From: Fiona Fitzgerald
Sent: 23 July 2014 08:42
To: Simon Davis
Subject: FW: Planning Consultation on: R/129/14/PL

APPLICATION **R/129/14/PL**

Site Address: Little Stars Ascot Way Rustington BN16 3SB

Description of Works: Rear extension

PROPOSED GROUND FLOOR PLAN

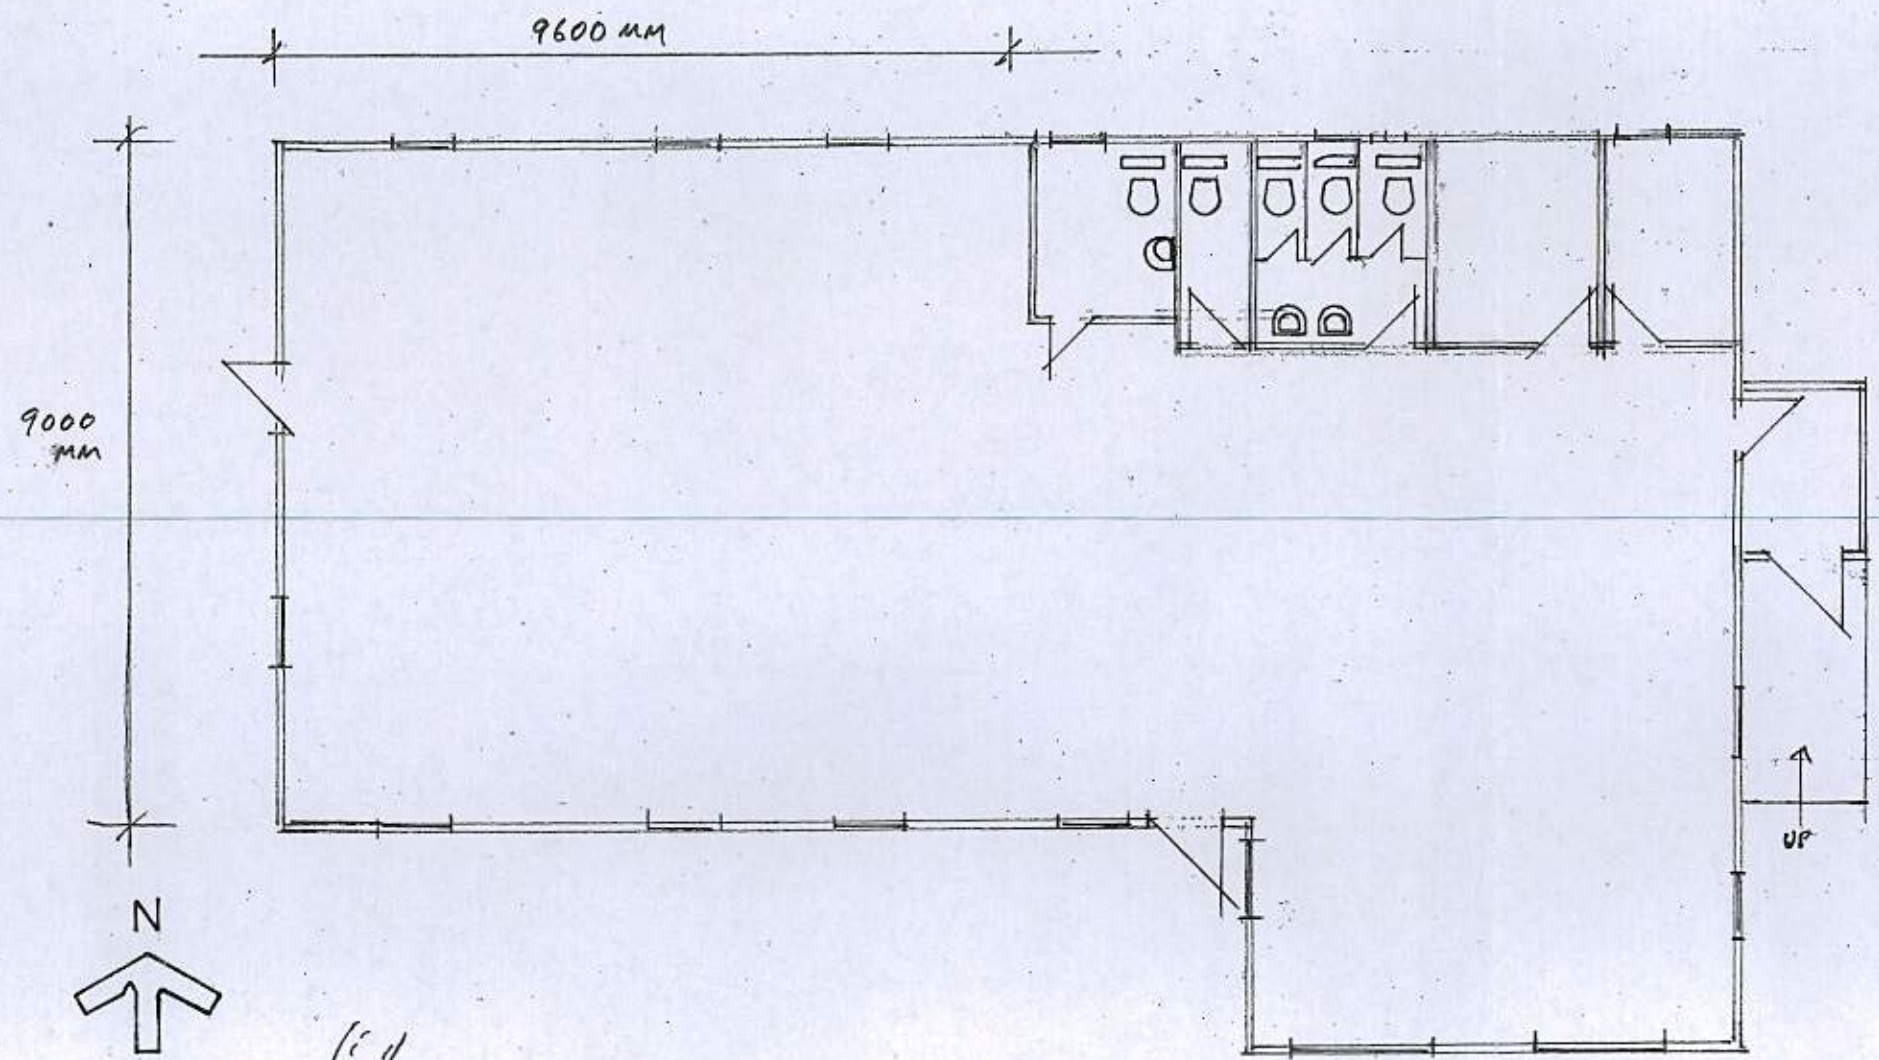
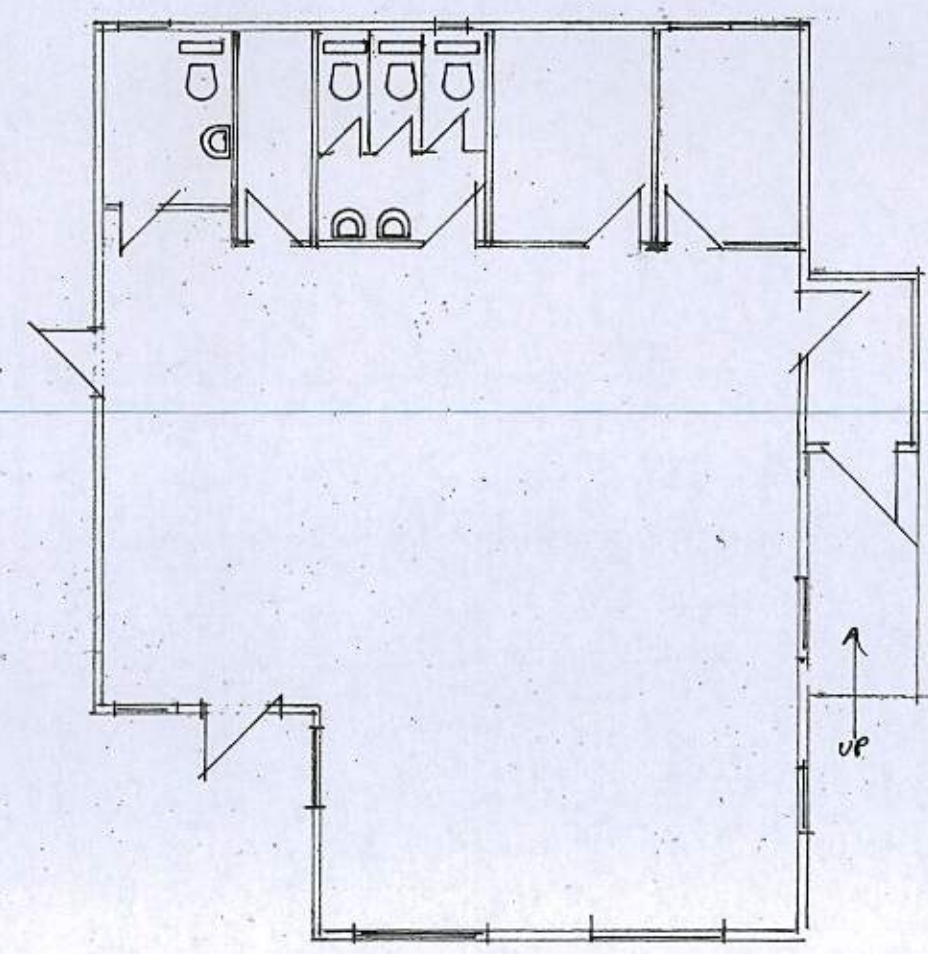
1. Please supply any details regarding the any changes to the kitchen. This includes any information regarding food preparation and any ventilation units.
2. Please supply details of outside play. Please specify where the children play, and how many children play outside at any one time, and for how long.
3. It would also be useful to know how many children currently attend the nursery, and how many it is intended will be able to attend once the extension has been completed.
